No.	Natural England's Relevant Representation -Appendix A - Generic Issues	RAG status Rel and WR Rep	Consultation, actions, progression	RAG status D1	Consultation, actions, progression	RAG status D2	Consultation, actions, progression	RAG status D3	Consultation, actions, progression	RAG status D5	Consultation, actions, progression	RAG status D8
Appendix A - Generic Issues												
1	We have continued concerns that not all the risks related to the proposal have been fully considered which means that, following the precautionary principle, we are unable to exclude, beyond all reasonable scientific doubt, no Adverse Effect on Integrity of the Wash SPA or The Wash & North Norfolk Coast SAC.		NE has advised the Applicant (in writing through our DAS service on 13th Sept) that unless the further information is provided to help determine the scale of the impacts, we will not be able to advise further on the appropriateness of any mitigation and/or compensatory measures and our advice will be more precautionary.		Ongoing		Ongoing		Ongoing		Ongoing

No.	Natural England's Relevant Representation - Appendix B - Offshore Ornithology	RAG status Rel and WR Rep	Consultation, actions, progression

DRAWN	MCP	CHECKED	AG	APPROVED	PS
DATE	19/03/2021	SCALE	AT A1	1:1000 & 1:250	REF: PB6934

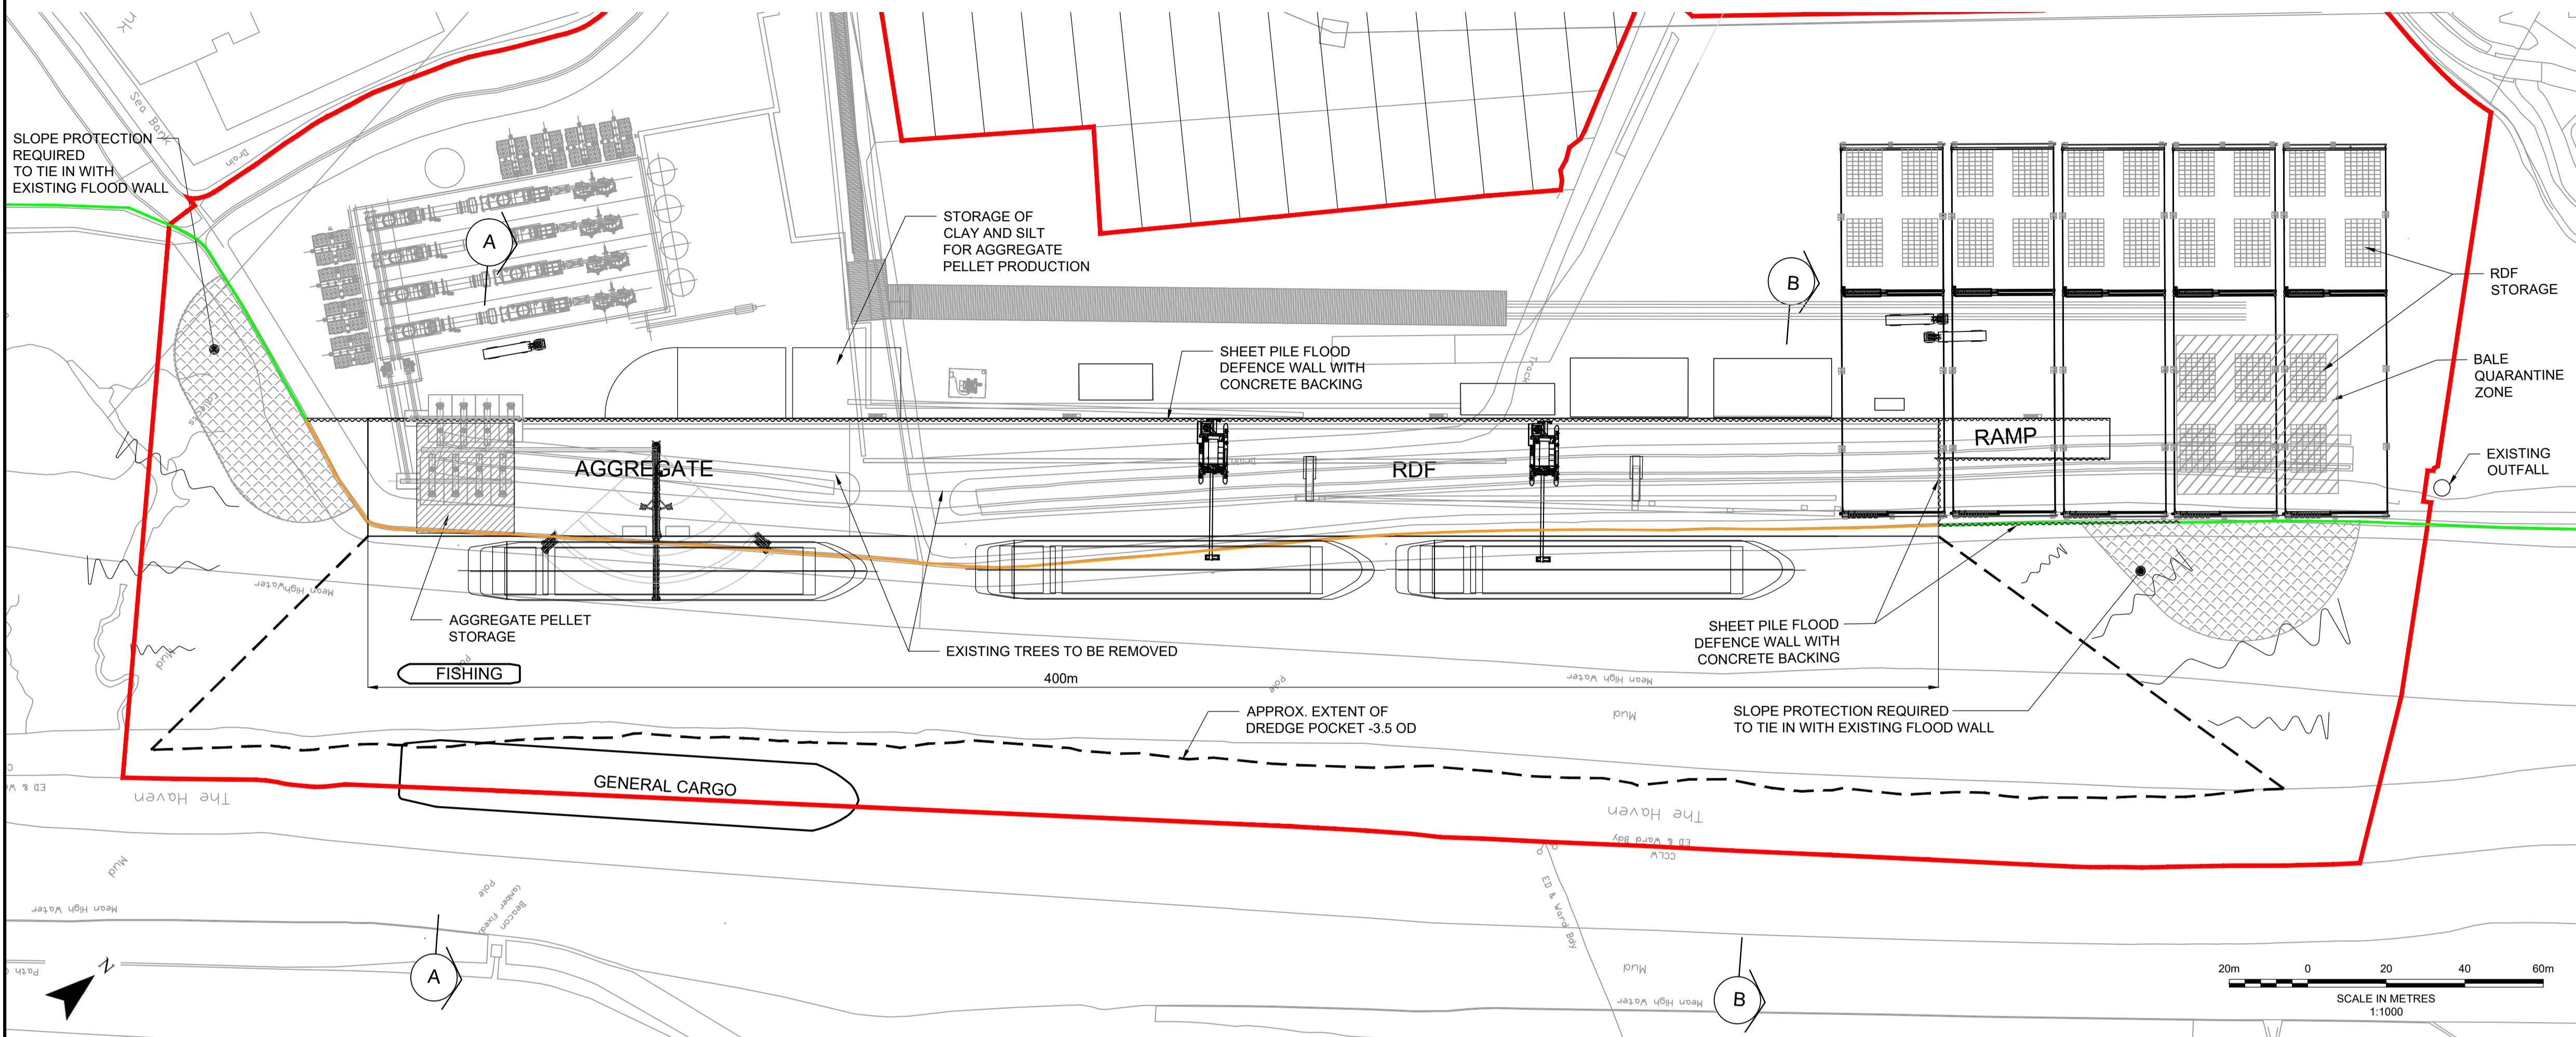
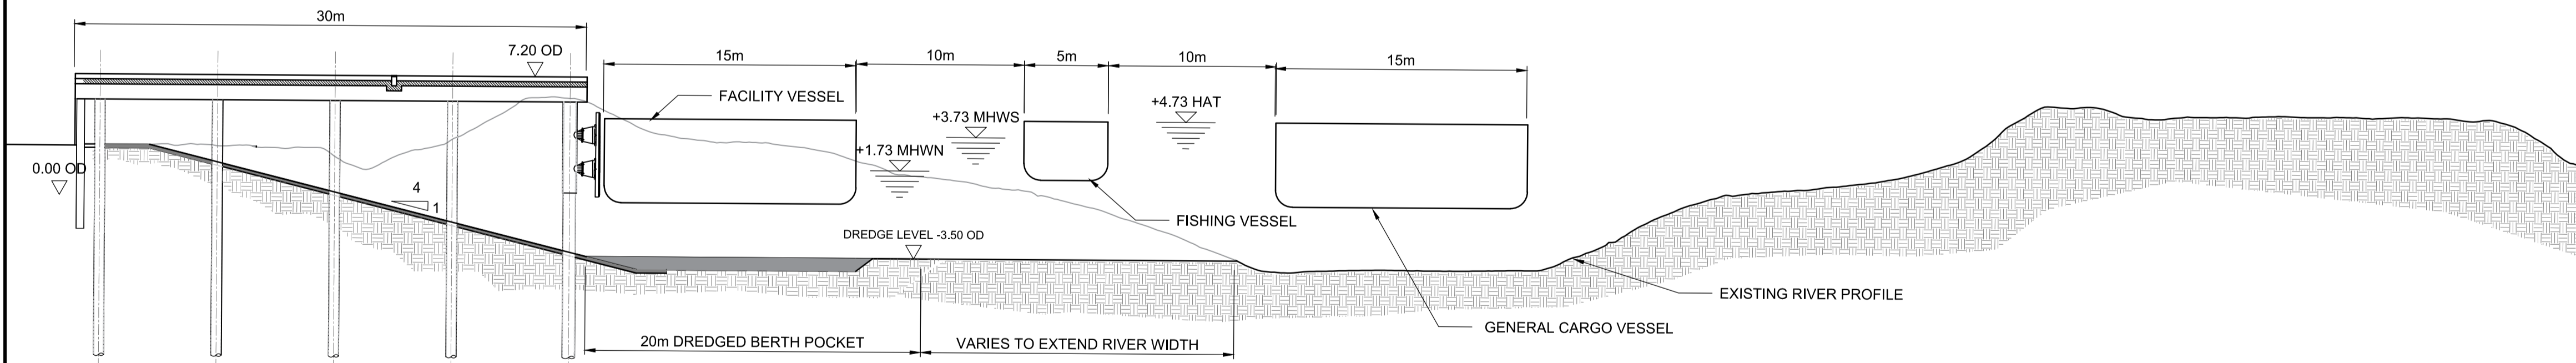
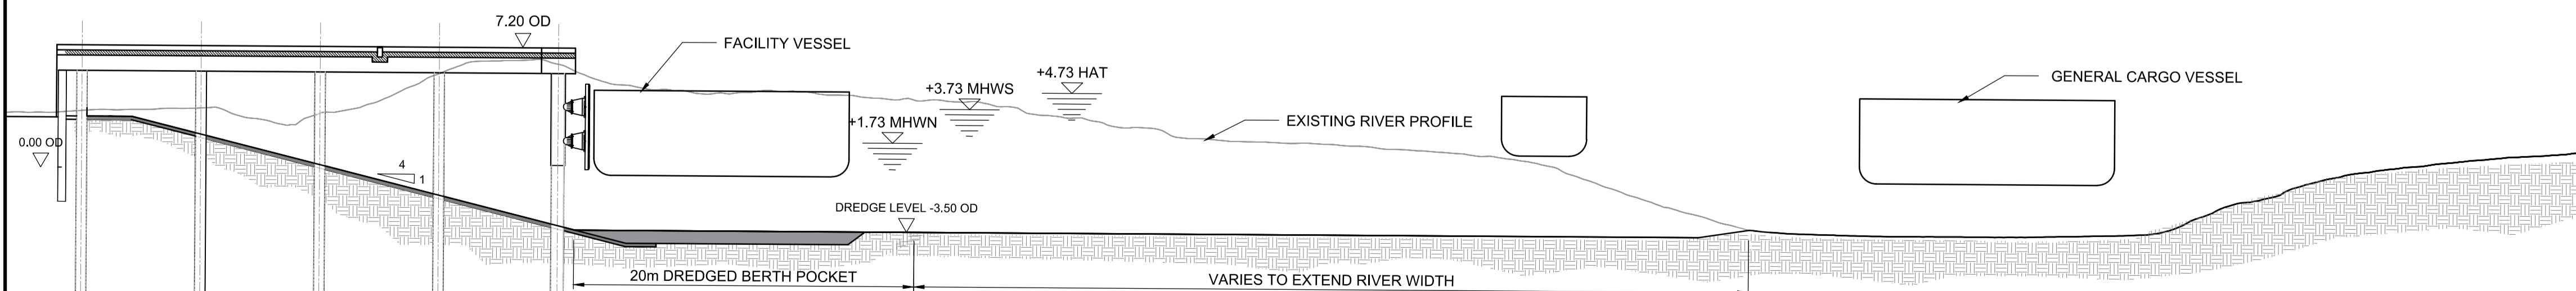
3	Natural England requests details on slope protection extending over 10,000m ² ? Fig 5.2 sheet 3 shows concrete facing on the mattress protection under wharf and possibly big rocks (no key) for slope protection. Natural England is concerned about the potential scouring of the Habitat Mitigation Area and also to the north, and on opposite bank.		On 13th August the Applicant informed NE that the effects of indirect impacts would be negligible (increase in tidal prism at the wharf is less than 2% of the tidal prism on the entire Haven). Natural England doesn't believe 2% change in the tidal prism is insignificant and therefore awaits further assessment to demonstrate that the impacts would be negligible.		No update		No update		This point remains outstanding		Please see NE Deadline 8 Appendix B5.

14	Natural England notes that this section describes area under wharf as being mudflat but Fig 5.2 sheet 3 appears to show it as having mattress protection (what is this made of? One of the drawings says concrete). Also mentions that saltmarsh species may re-establish here under raised deck of wharf. However, we advise that saltmarsh habitat requires high light levels, so we believe this is unlikely.		NE advised the Applicant that it remains unclear as to how the area under the Wharf has been taken into consideration in the assessments.		No update		No update		This point is now resolved in the updated addendums.			
15	Please note that width given here is 30m (previous section – 17.8.7 says 40m).		NE await addendum to ES.		No update		No update		This point is agreed.
